From: Martyn White <Martyn.White@arun.gov.uk> **On Behalf Of** Conservation Officer
Sent: Friday, July 29, 2022 4:48 PM
To: Maria Tomalova <Maria.Tomalova@arun.gov.uk>
Subject: Y/52/22/DOC

Y/52/22/DOC

Stakers Farm North End Road Yapton BN18 0DU

Approval of details reserved by condition imposed under Y/105/19/PL relating to conditions 3-flint flooring and stall dividers, timber ceiling details, 4-flint flooring details, 5-surface water drainage and 9-electric vehicle charging.

DRAWING TITLE
PROPOSED SITE LAYOUT

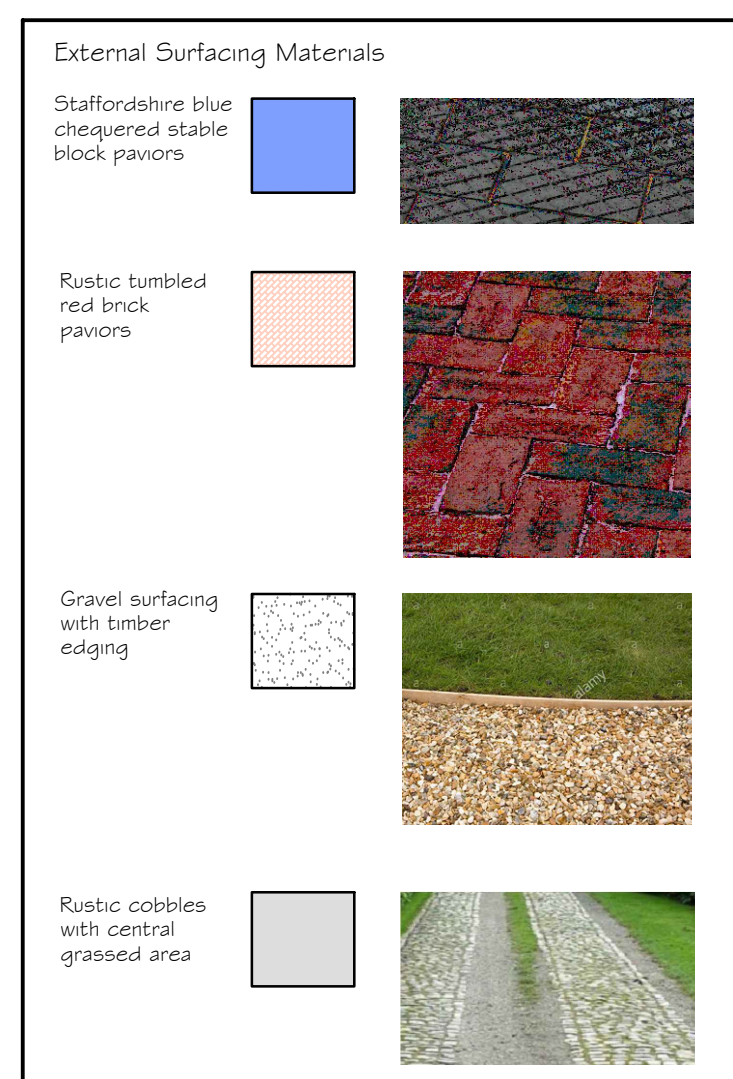
At present a number of the plans supplied DOC application (such as for the site layout and the barn garage) are those supplied for the current application and do not relate to application identified in the description i.e. Y/105/19/PL. There have been a number of changes in the proposals since the original approval, and it is not possible to use the current plans to assess the details required of the previous application.

Please can the correct plans and information be supplied as soon as possible so that I am able to provide comments and the development can commence!
